CITY OF ALBUQUERQUE

RE: Villa Firenze, (C-20/D003E)
Engineers Certification for Release of Financial Guaranty
Engineers Stamp dated 06/18/2007
Engineers Certification dated 7/19/2007

Re: Villa Firenze Grading and Drainage Plan
Engineer's Stamp dated 6-18-07 (C20/D3E)

Re: Villa Firenze Grading and Drainage Plan
Engineer's Stamp dated 8-17-06 (C20/D3E)

VILLA FIRENZE

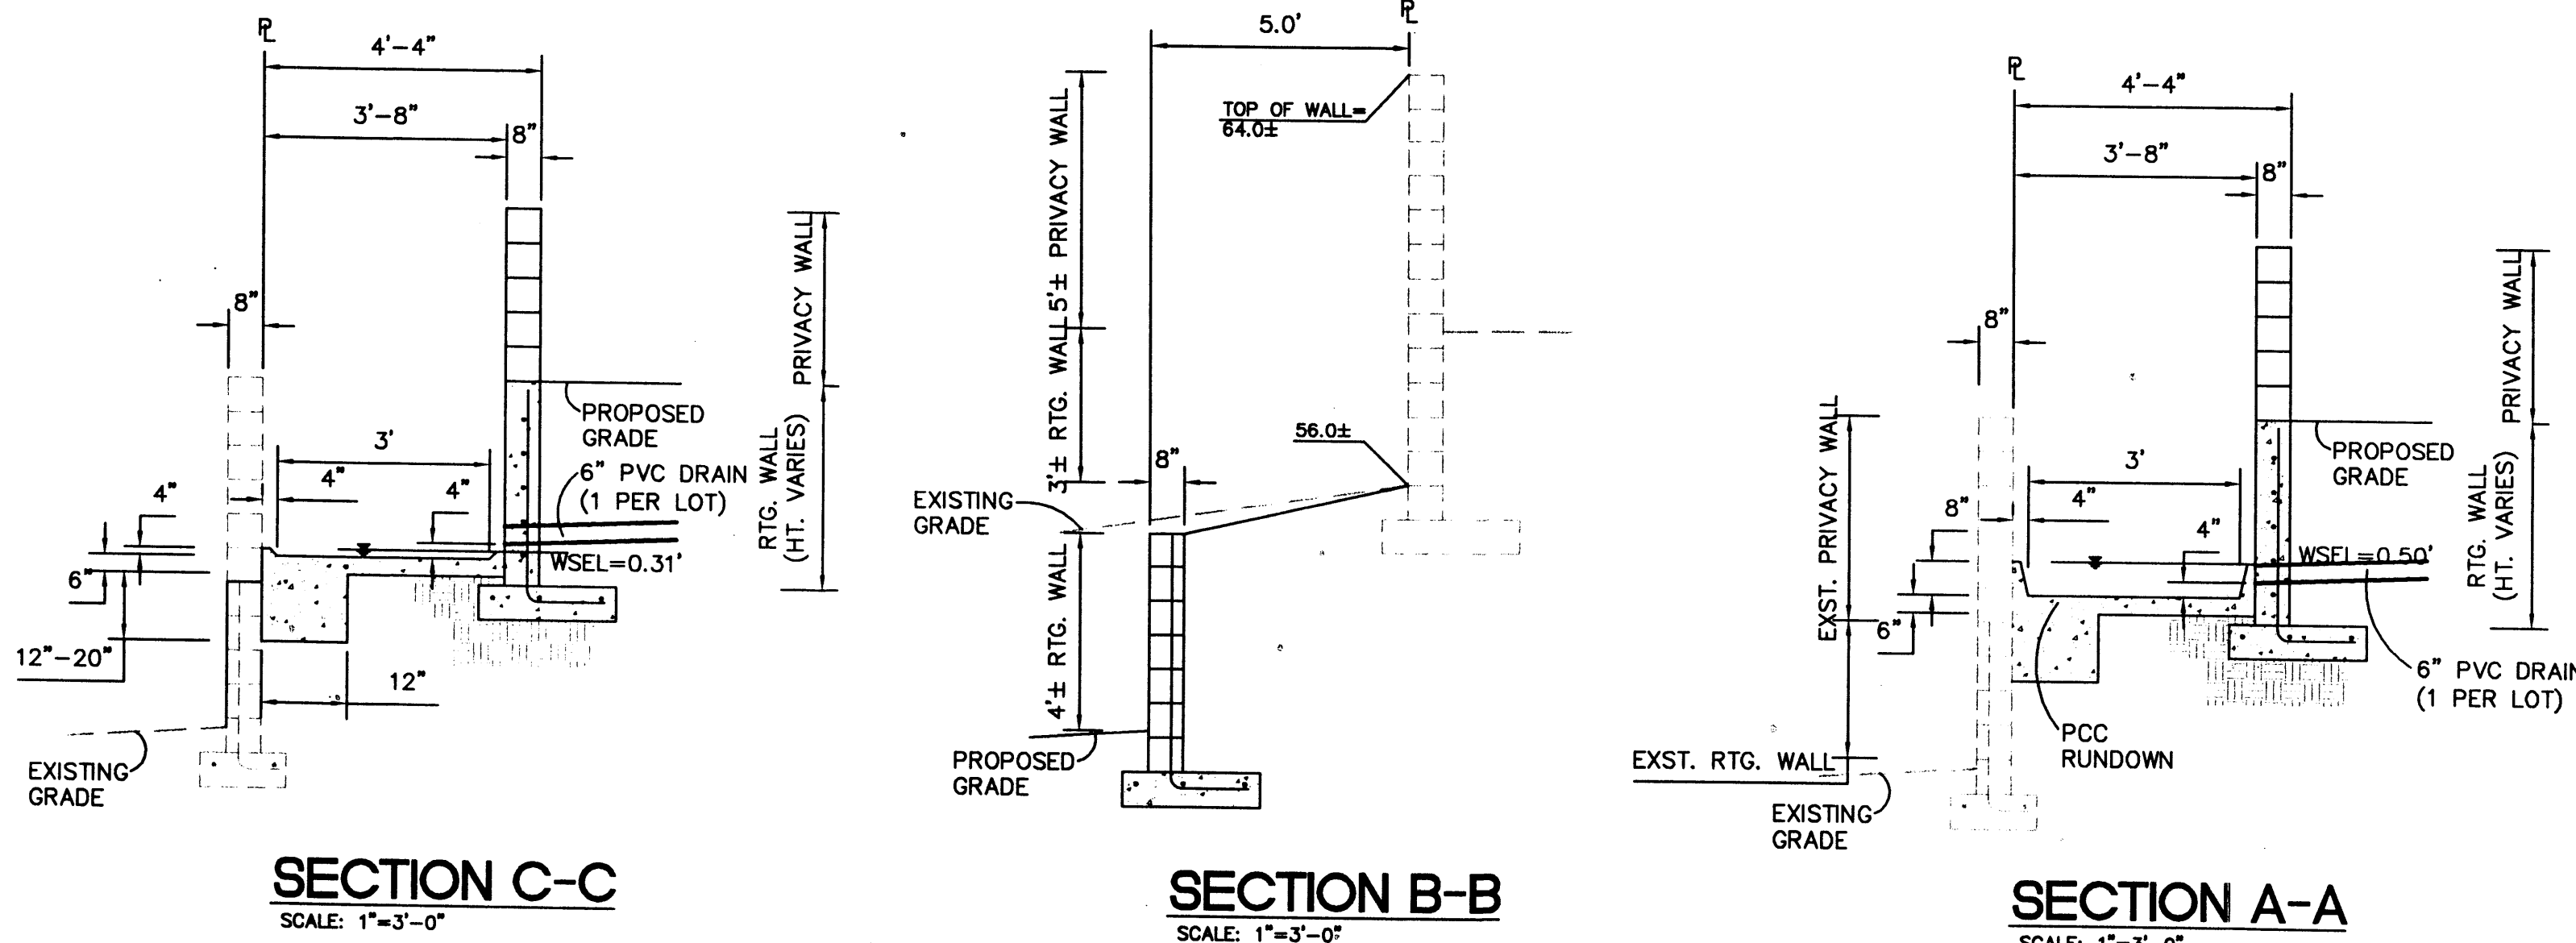
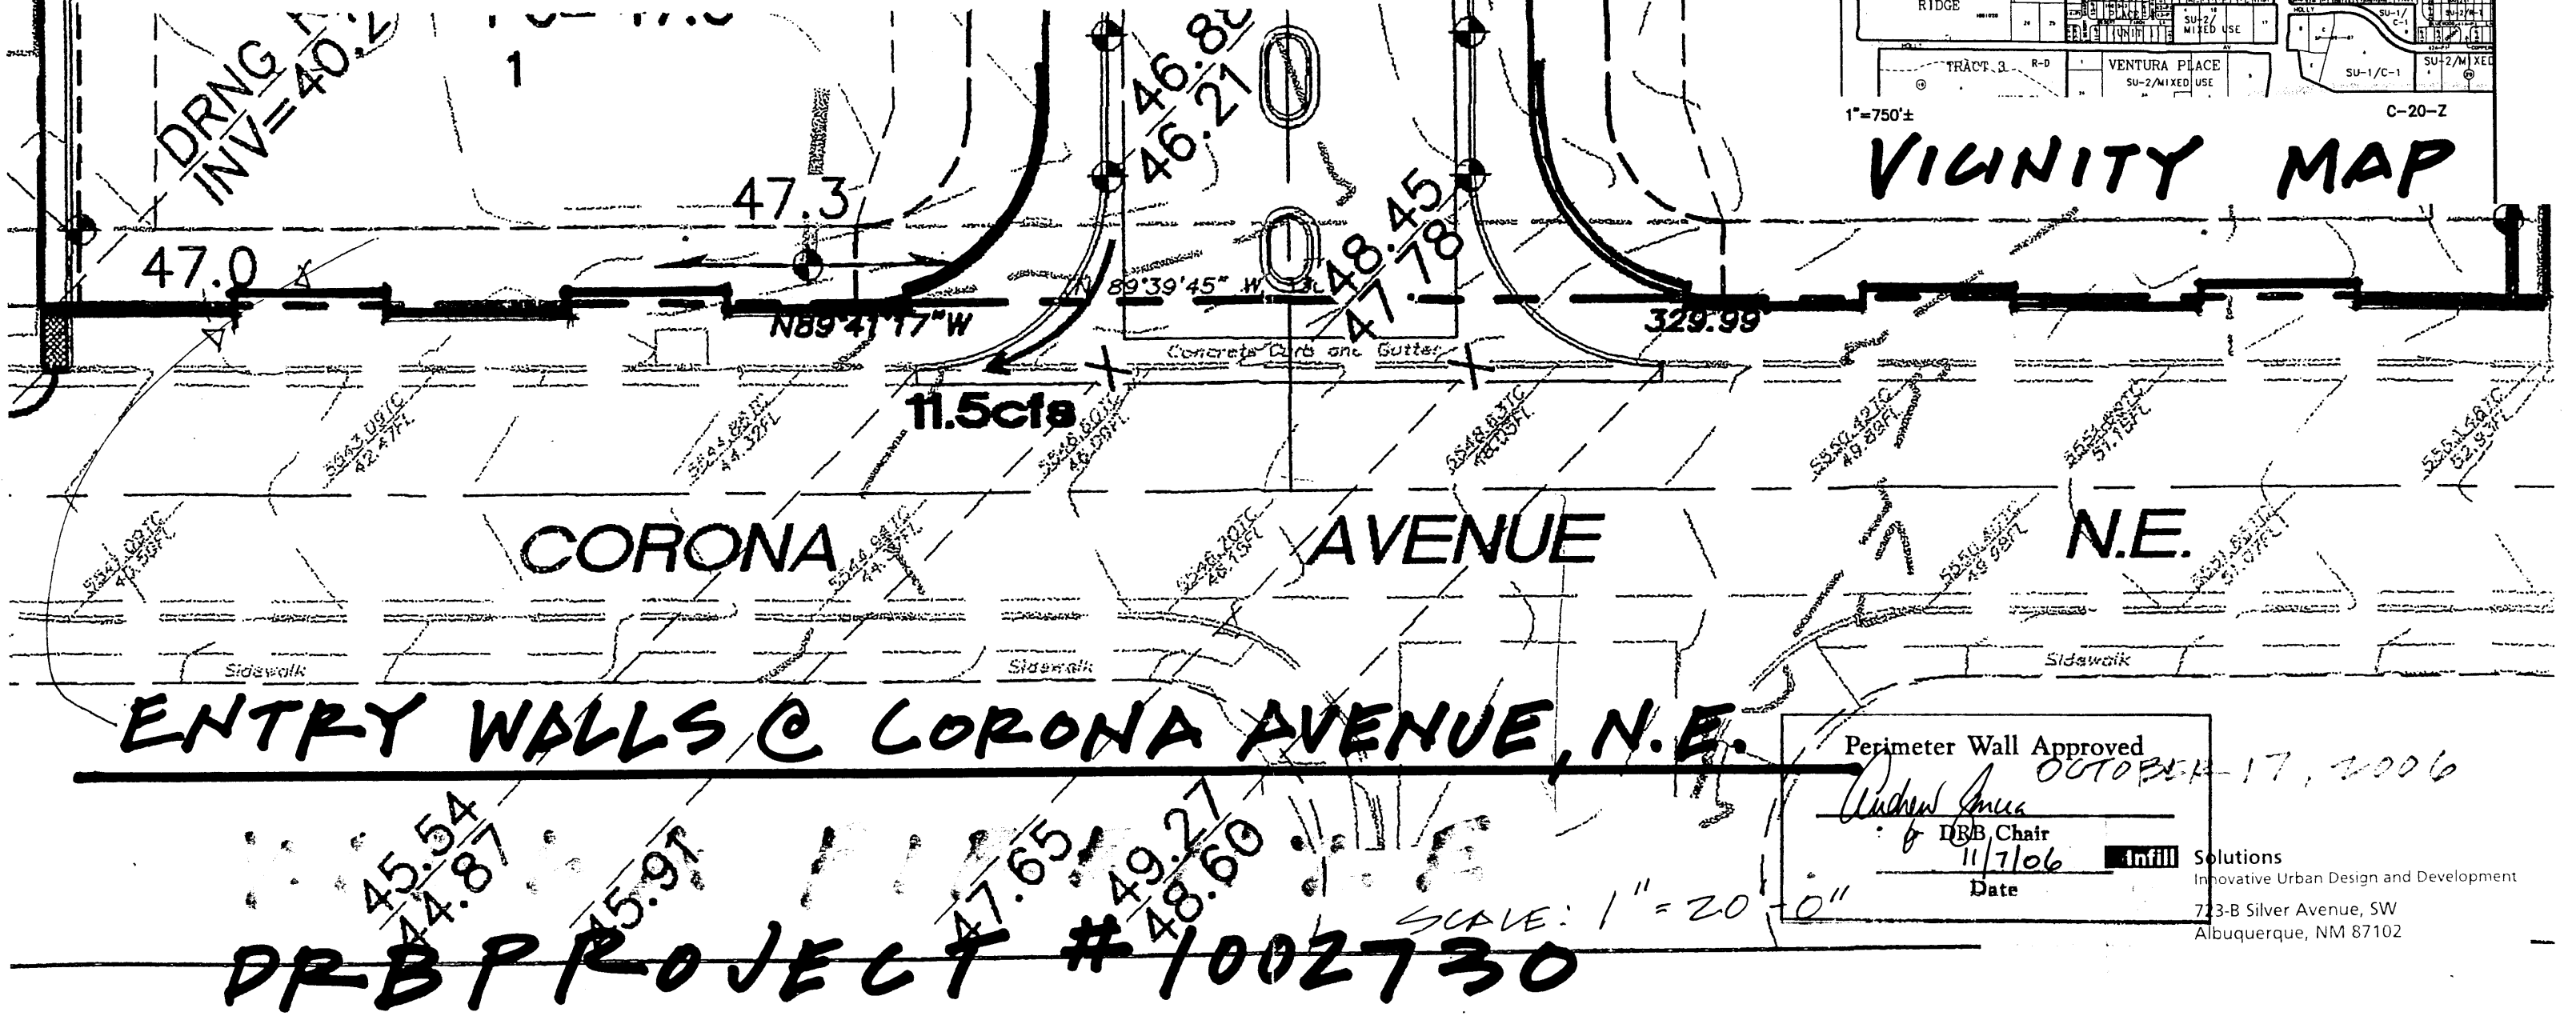
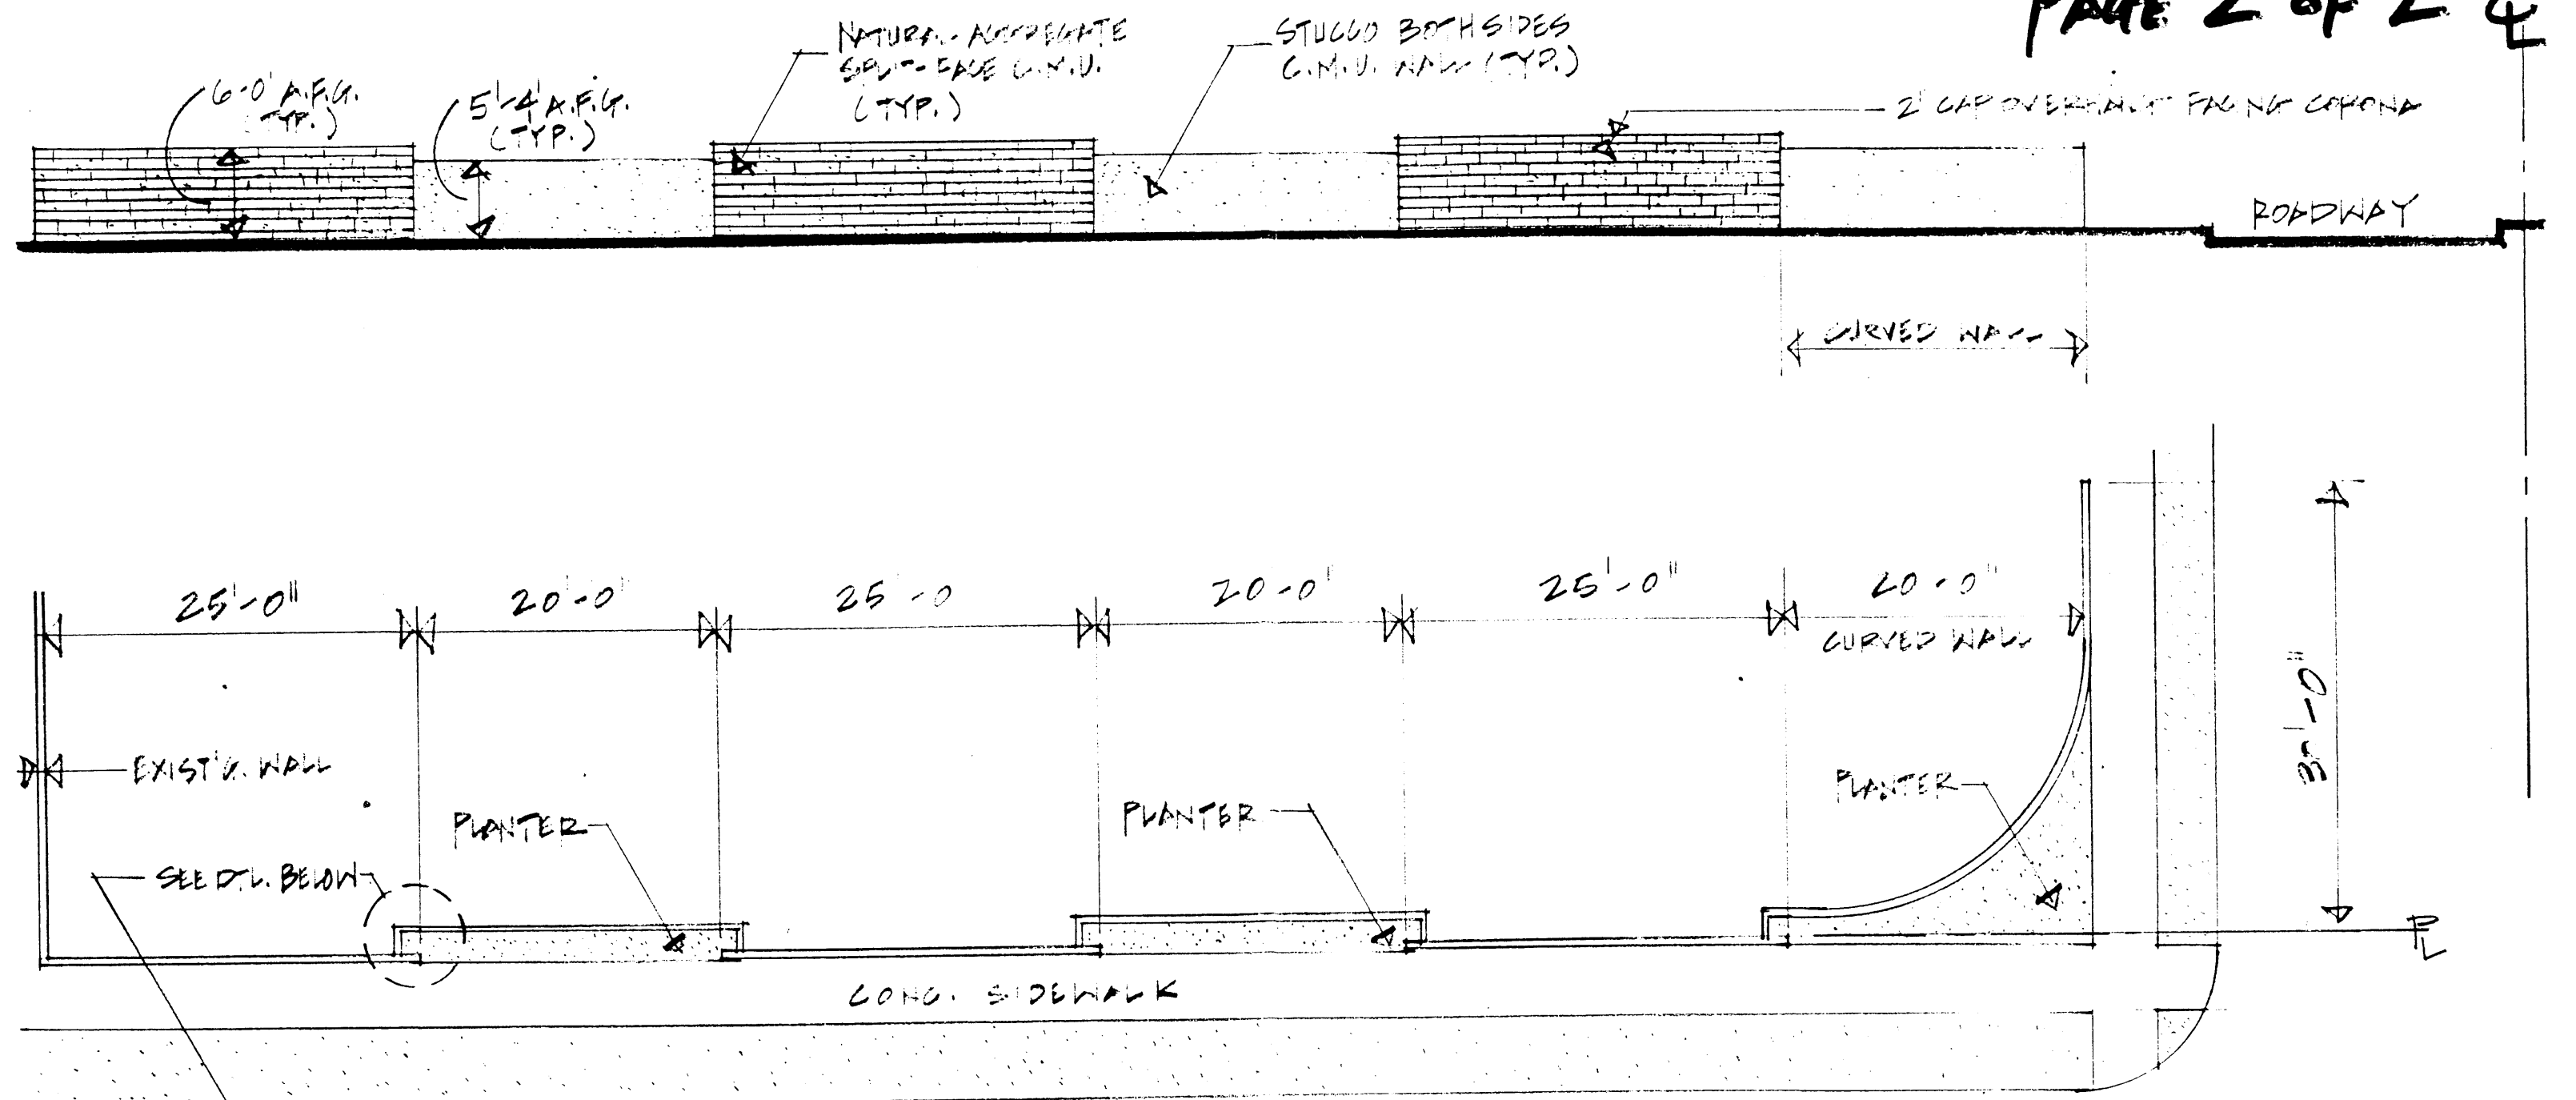
- Adjust the % land treatments using 80% for land treatment D and calculate the peak discharge for Basin W. Update the rectangular channel calculations and the height/width of the channel as necessary.

- Provide calculations for the capacity of Firenze Lane?
- How deep will the water get in the concrete rundown? The lip on the rundown needs to be high enough to contain the 100-year 6-hour storm.
- There appears to be a typographical error for the ground treatment for proposed Basin W. The basin appears to be 90% Treatment D, not 50% as stated. Please reassess the land treatments for Basin W. Update calculations as necessary.
